Application no: **3/2021/0556**

Address: **74 Higher Road Longridge PR3 3SY and land to the rear**

Proposal: **Application for reserved matters consent (appearance, scale, landscaping and layout) pursuant to outline planning consent (ref 3/2016/1082) for the demolition of 74 Higher Road and construction of up to 123 houses on land to the rear.**

The Local Highway Authority have viewed the plans and highway related documents and have the following comments to make:

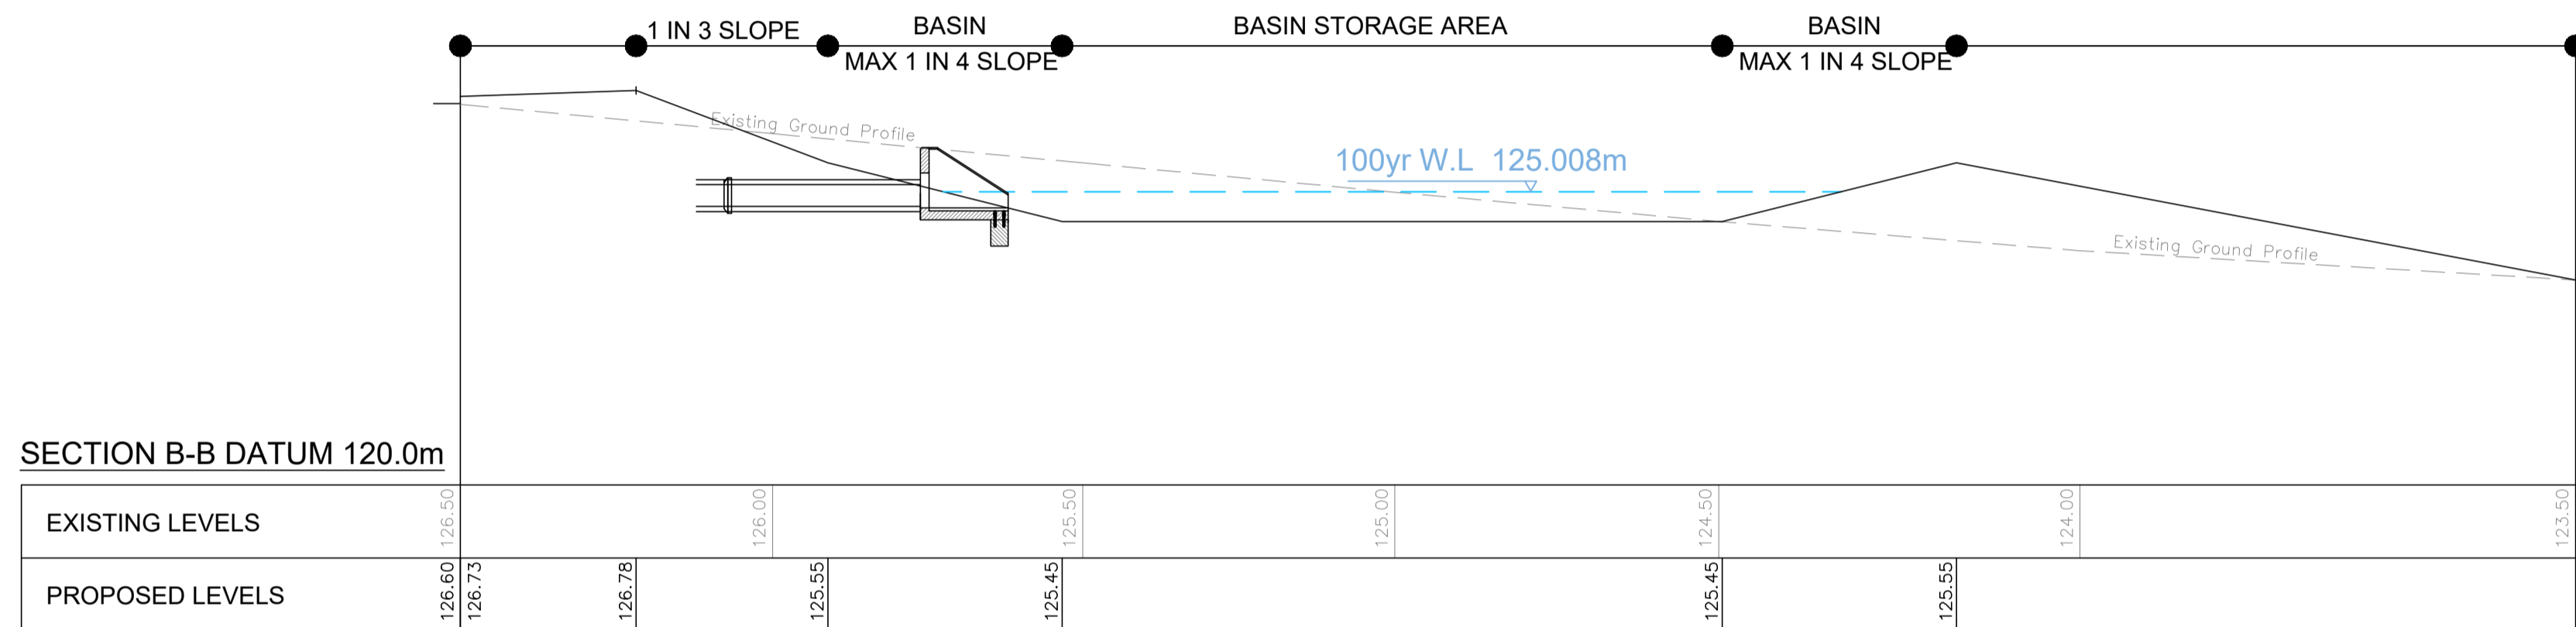
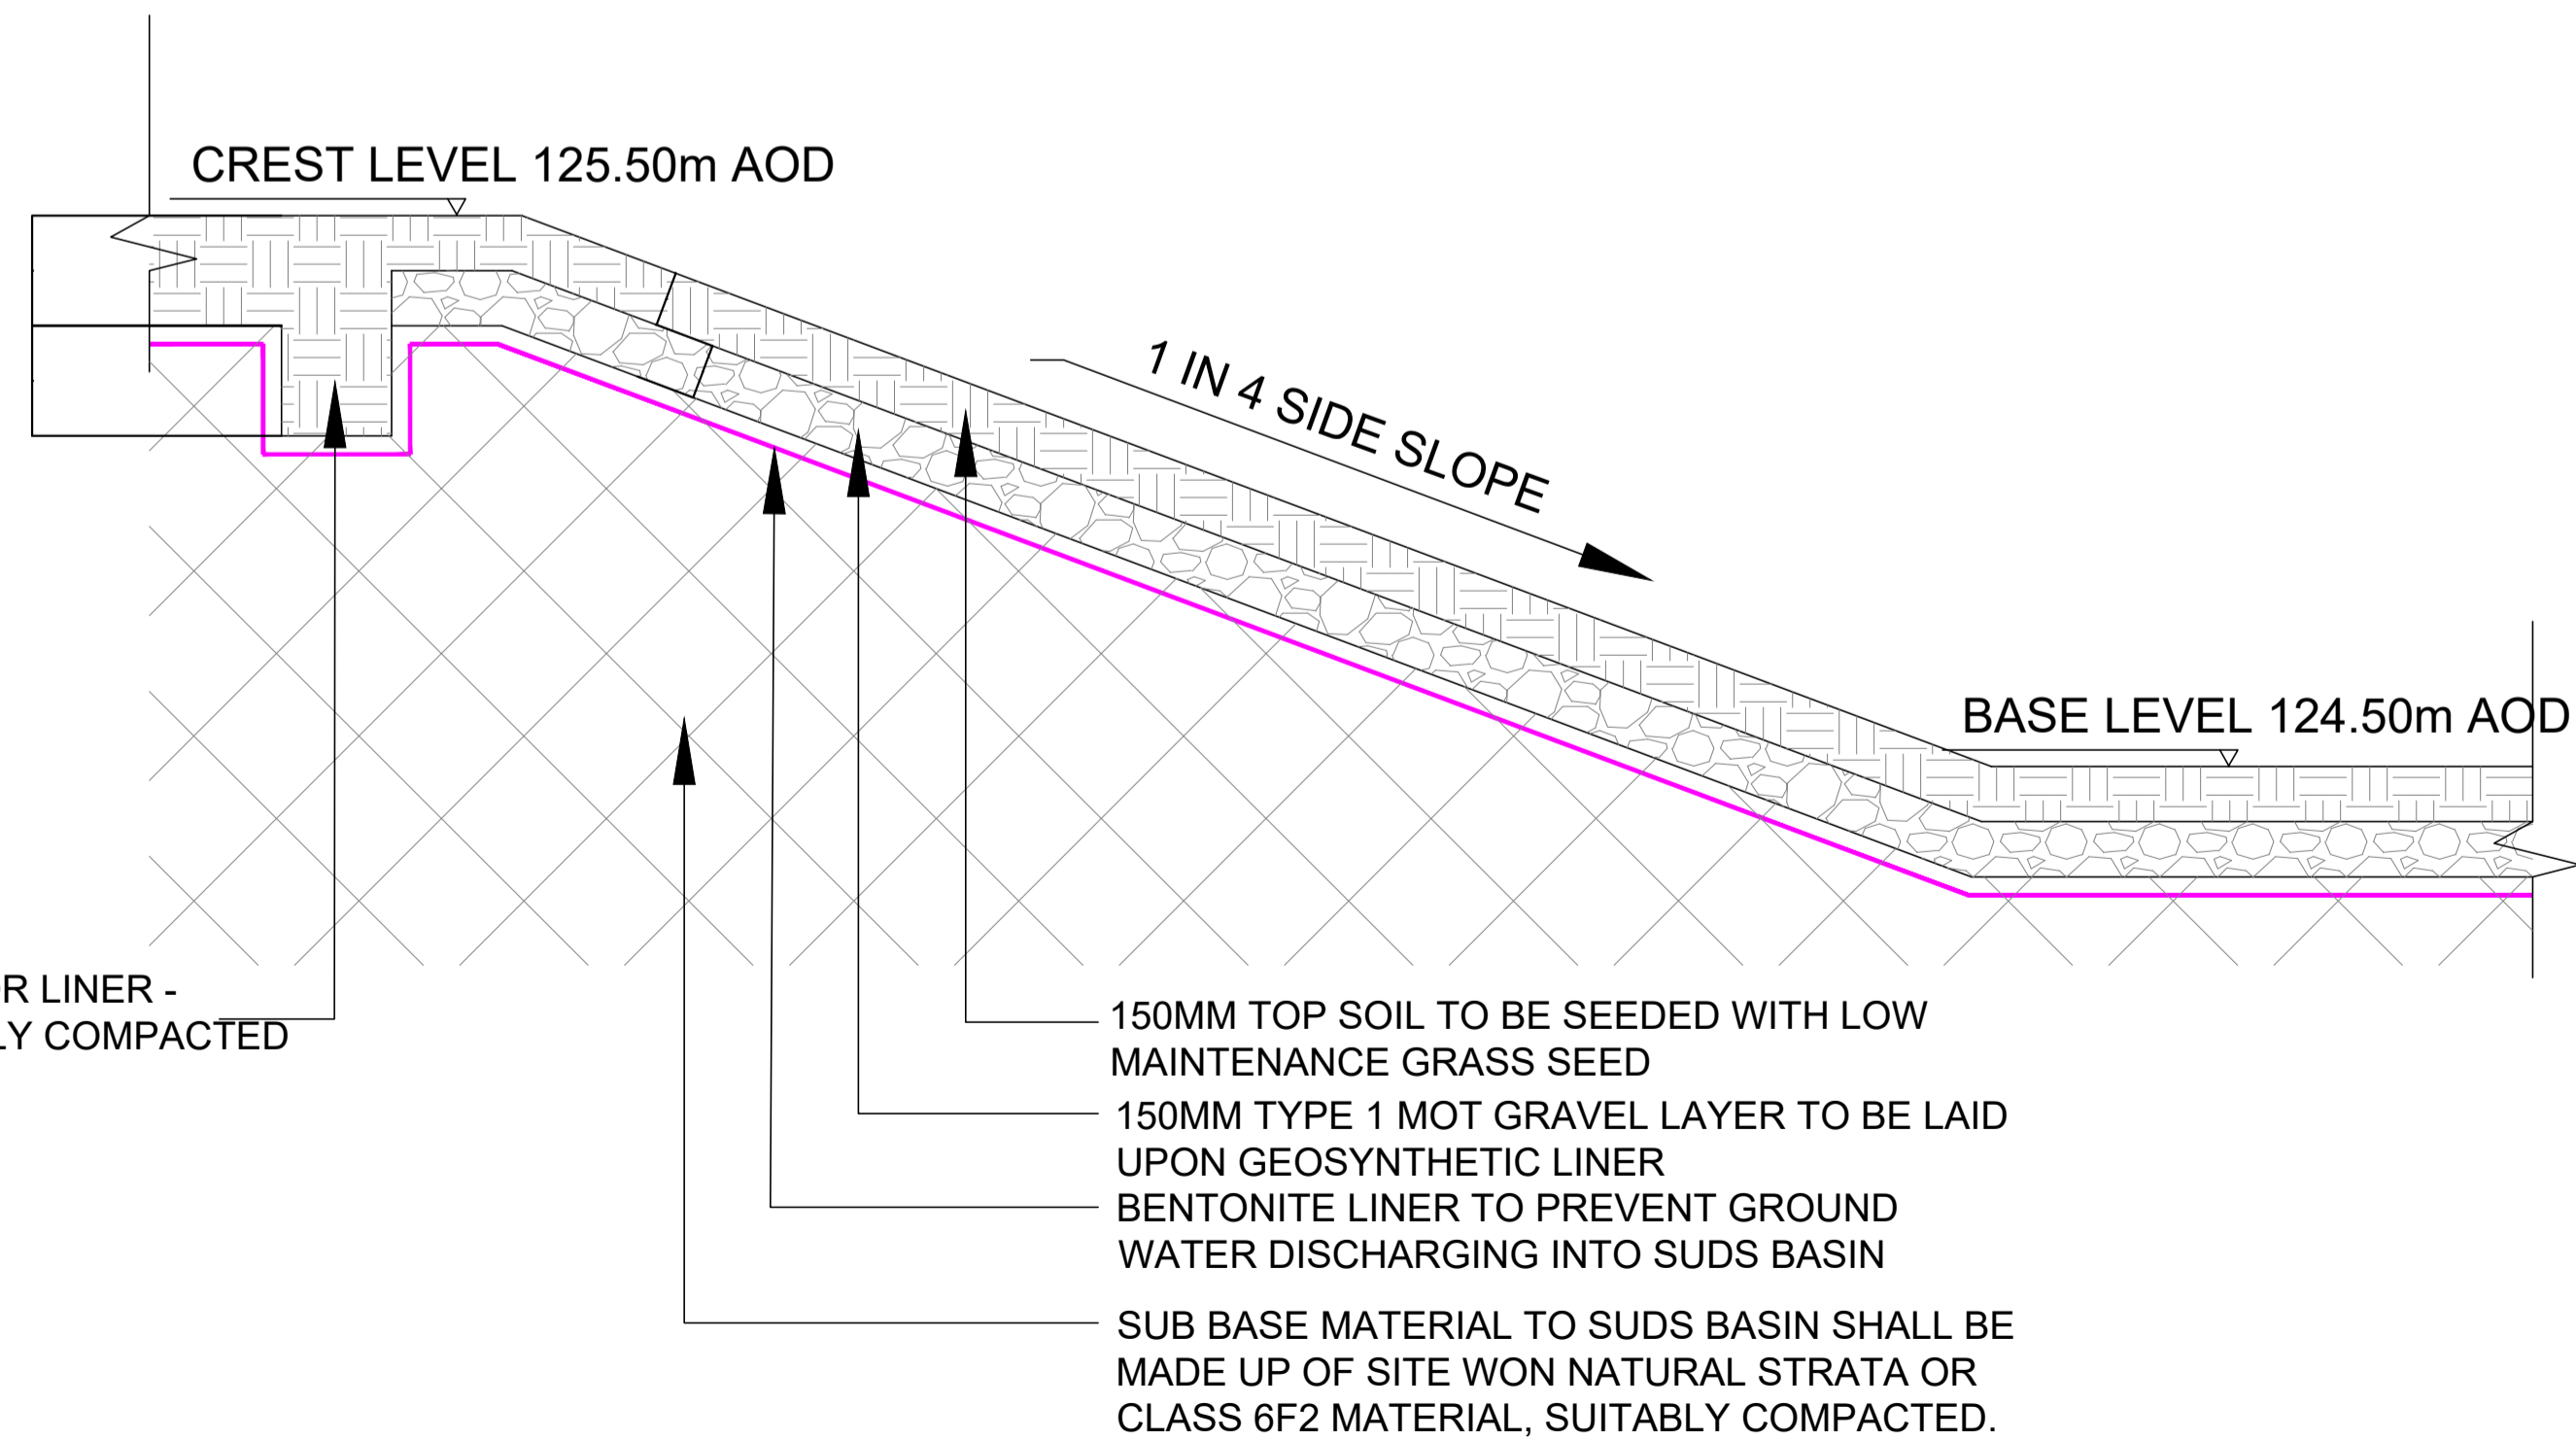
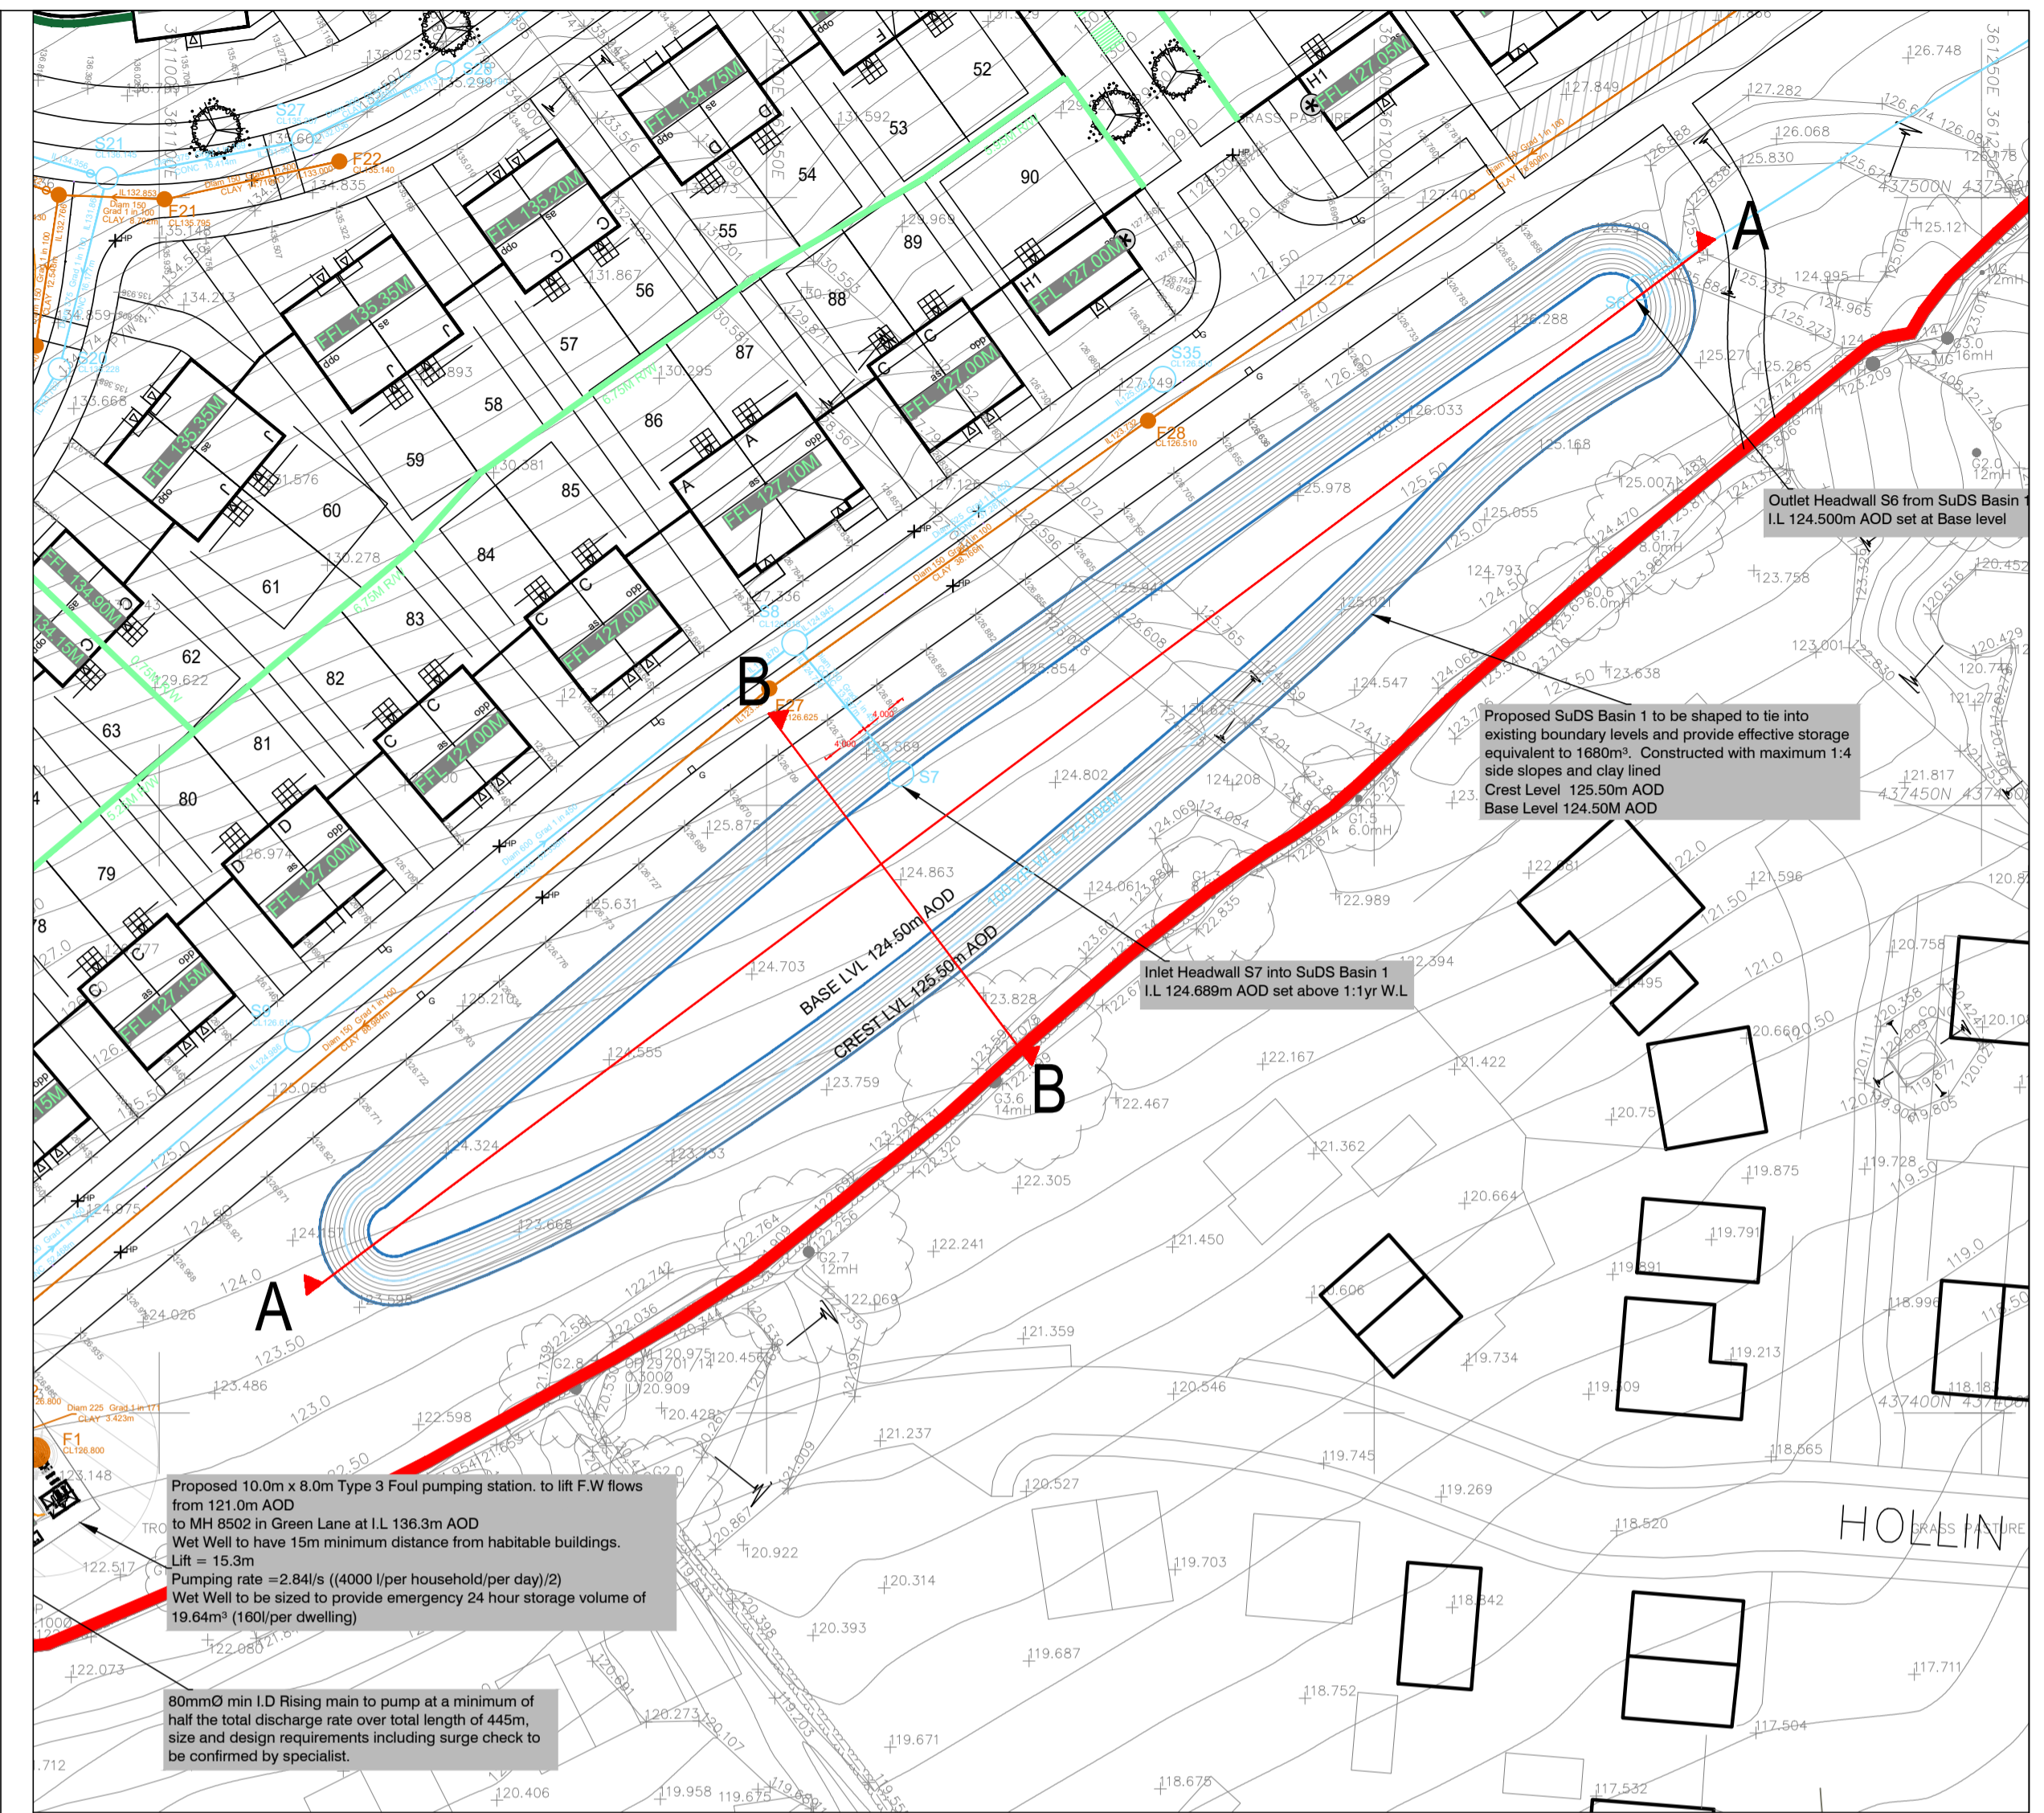
Due to the gradient of the site, the LHA require further site sections. These site section should be of the two attenuation basins, as shown on the drawing.

Should the gradient in these locations be steeper than 1 in 2, then the LHA will require a Structural Agreement.

Furthermore, due to the gradient of the site, a Vehicular Restraint Assessment is required next to the attenuation basins as well to ensure that vehicles have a safe passage where the gradient is at its steepest.
